MEMO

Joe Russell-Wells
Greenspace Engineering and Emergency
Planning

THE WOODGATE CENTRE WOODGATE ROAD WESTERGATE PO20 3GU – AL/69/11

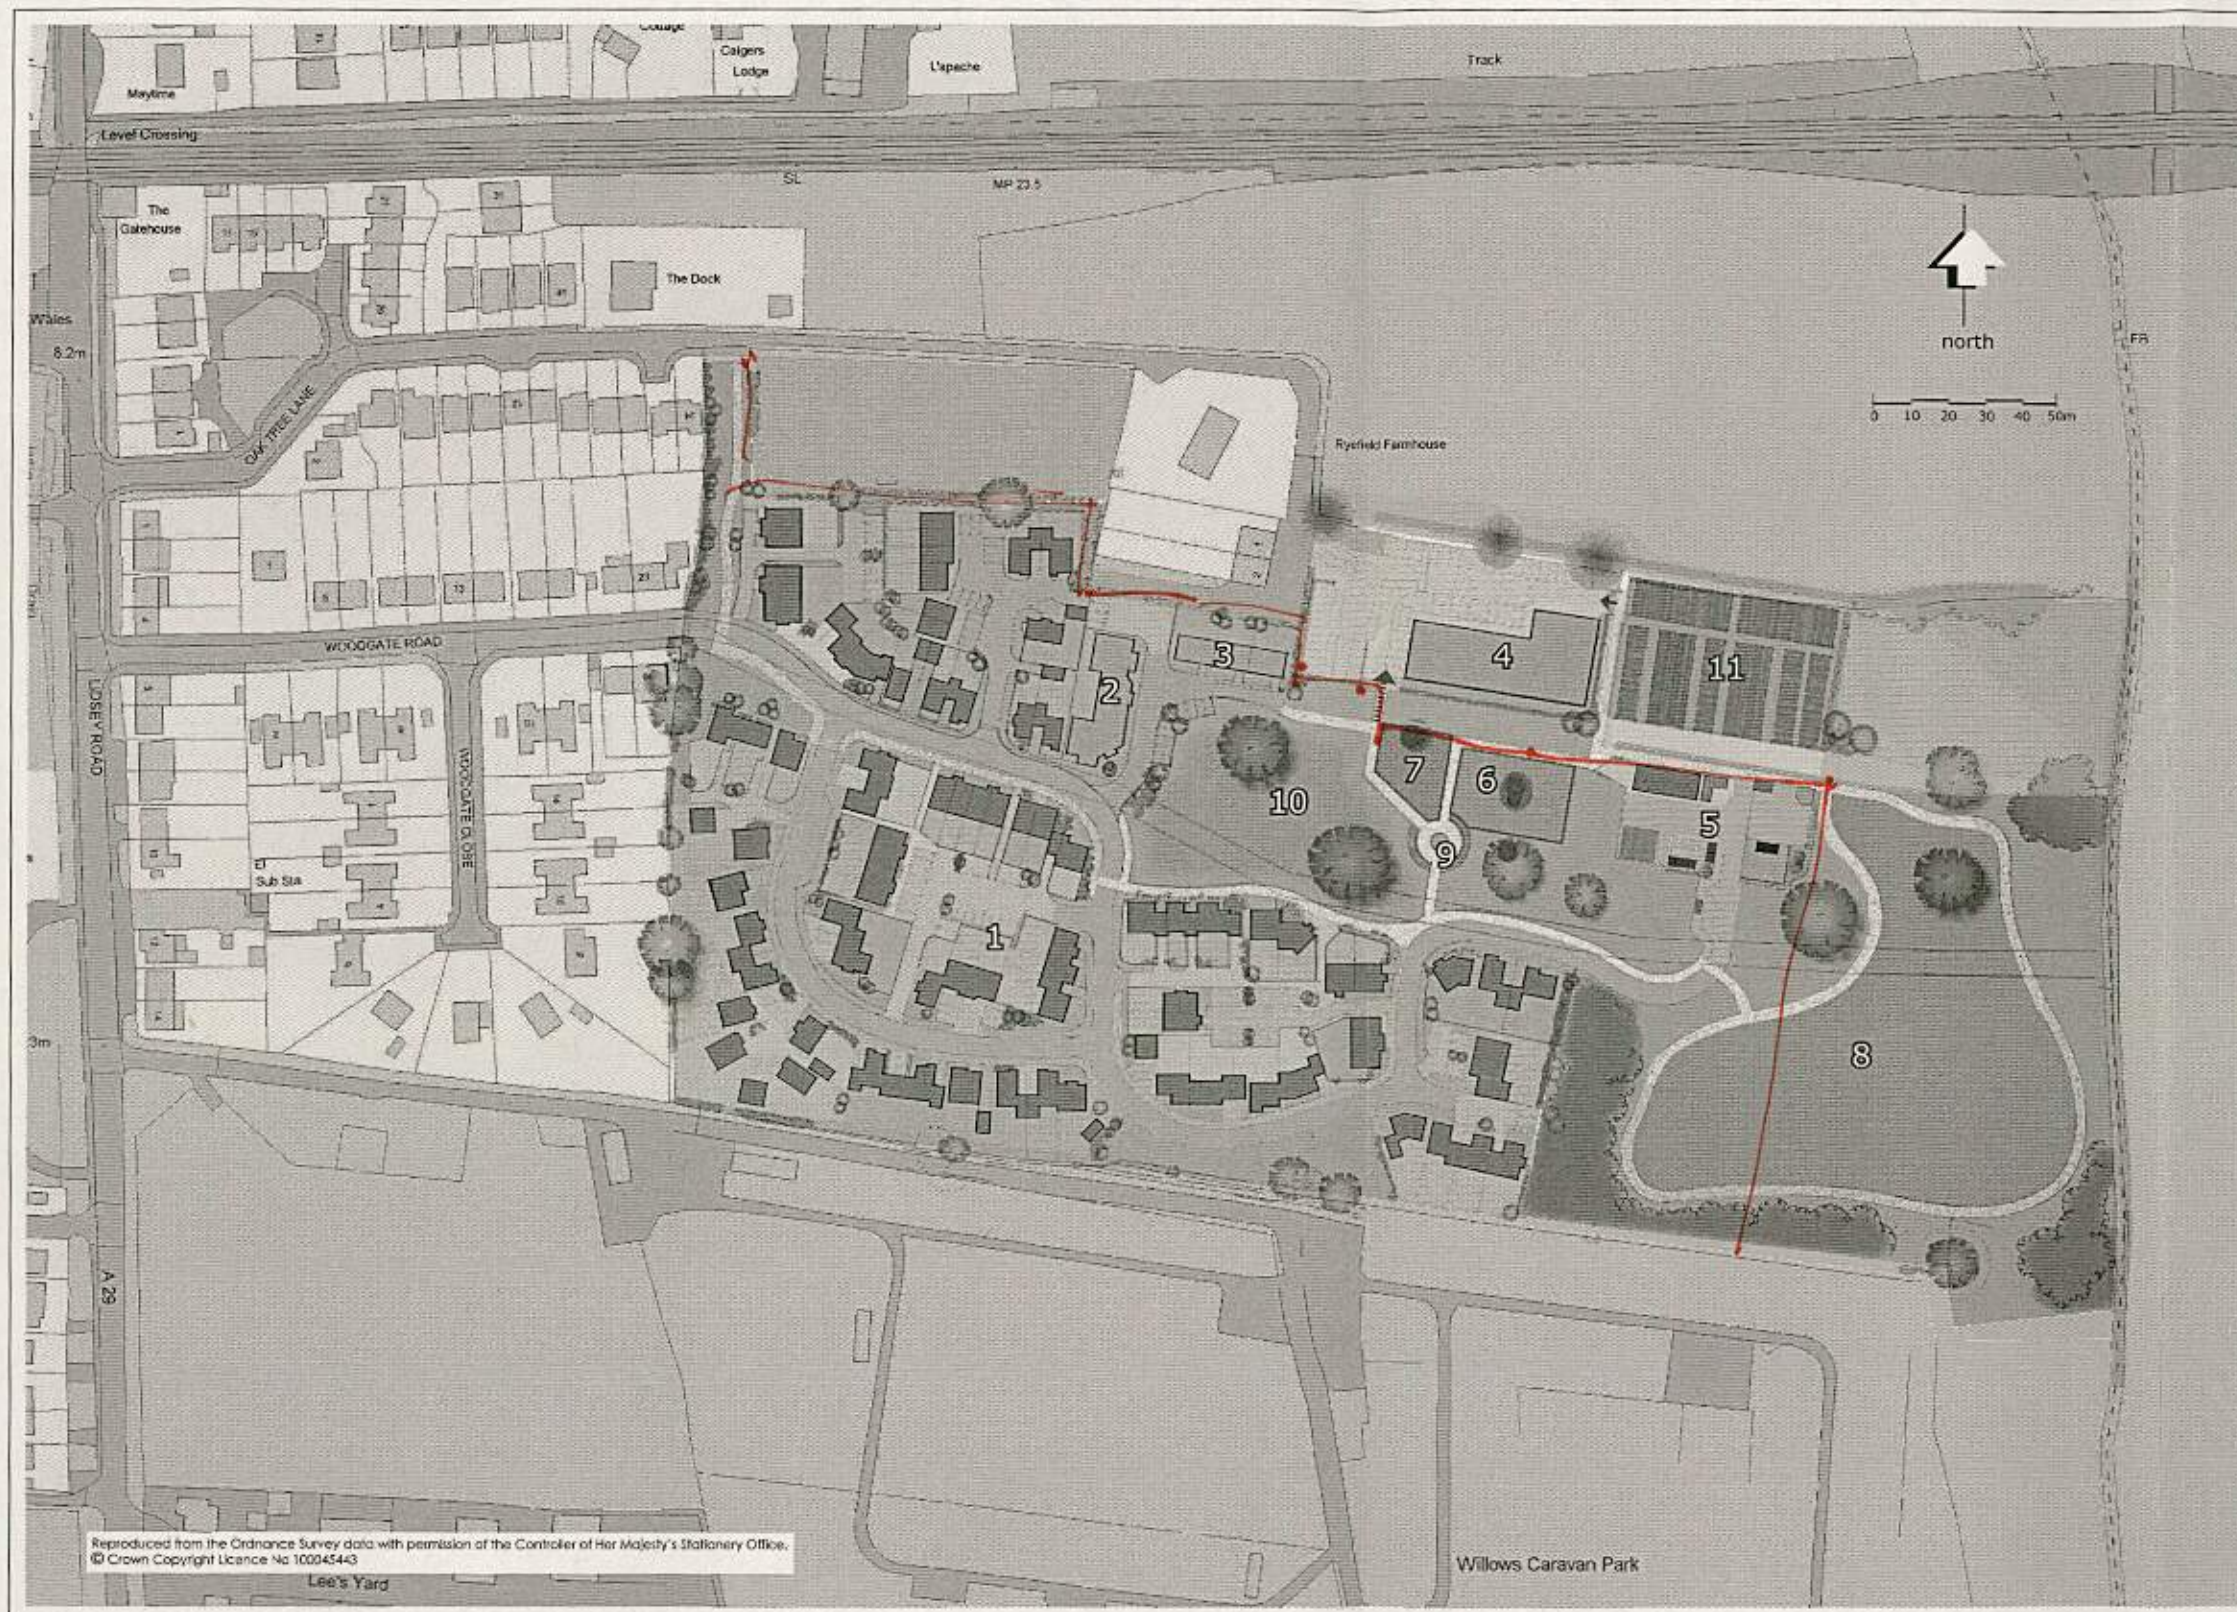
A development of up to 100 houses will produce a population of 220 people. There is a requirement of an area of 9262 m² of public open space with this development. The figure stated as being provided at 7115 m² within the red edge of the development is therefore insufficient. The adjacent open space area is noted, but unless the red edge is extended to include part of this area the proposal in terms of open space provision is inadequate.

It is noted that the open space areas have been centred around areas where trees exist on site which appears a sensible approach. However this has resulted in several fragmented areas. This together with the requirement for a large area of the open space to be for outdoor sports and that there is currently an under provision underlines that the proposed open space provision is inadequate.

The provision of play for the development is adequate. The location near housing is questionable, their location is critical to their success or failure. They must be located allowing a buffer of POS between these areas and housing, in accordance with FIT standard (formerly NPFA). The detail of provision would need to be conditioned or form part of a reserve matter with any permission.

Only minor indicative planting has been illustrated with the plan and is therefore inadequate. This would result in poor quality open space as show at present.
